From: M HARVEY [REDACTED]
Sent: 30 September 2018 22:32
To: Amber Willard
Subject: Re: fp/190/18/t

From : [REDACTED]
Date : 24/09/2018 - 09:37 (GMTST)
To : [REDACTED]
Subject : fp/190/18/t

I have received an Arboriculturalist response regarding your application at land between 3 and 9 Old Rectory Gardens, Felpham. Unfortunately the tree officer was unable to identify the tree you specified as a Bay tree and therefore is unable to determine that element of the application.

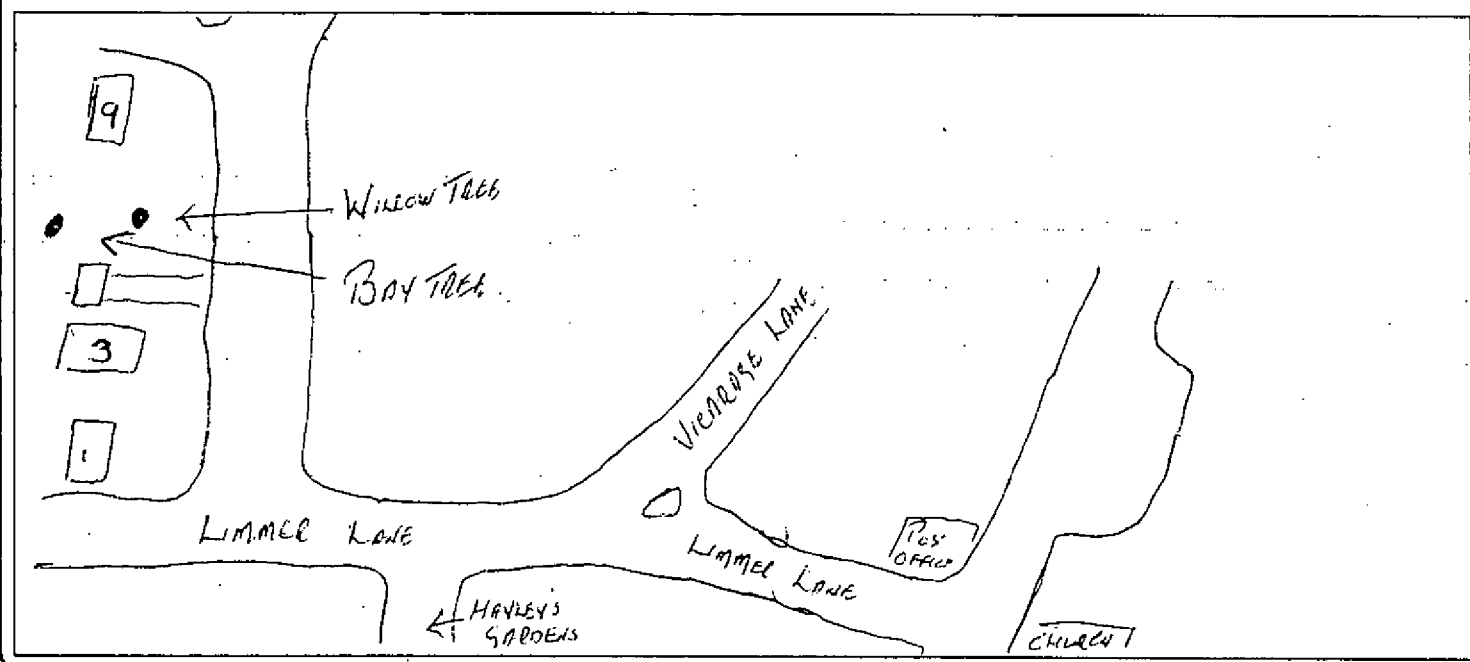
The willow tree is correctly identified and plotted reasonably accurately on the plan. I am able to make a determination on this element of the application although I would advise the applicant subsequently considers stating an intention to remove low growth above the adjacent road to a minimum height of 5metres and back to the kerblne, in a new application. On completion, that work would meet their obligation to ensure unobstructed access along the public highway for high-sided vehicles.

The only bay tree (*Laurus nobilis*) in the immediate locality is a small specimen of no more than 5metres height, growing approximately 8metres due southeast of the aforementioned willow and adjacent a boundary fence. It grows from within the rear garden of 24 Limmer Lane. This is a considerable distance from the position marked on the applicant's plan. The mark would seem to correspond with the position of a mature silver birch tree. The information provided in relation to the bay tree does not correspond with my observations on site, so I am unable to determine this element of the application.

I suggest the applicant re-submits an application following advice from a Tree Specialist who will be able to correctly identify and accurately plot on a map all trees intended for work. This must be supported by an appropriate and comprehensive work specification, to enable us to make an informed decision.

Following his comments, I am unable to recommend a decision on the Bay tree, I am however able to amend the description of the application to remove the proposed works to the Bay tree. This would allow no objection for the works to the Willow Tree.
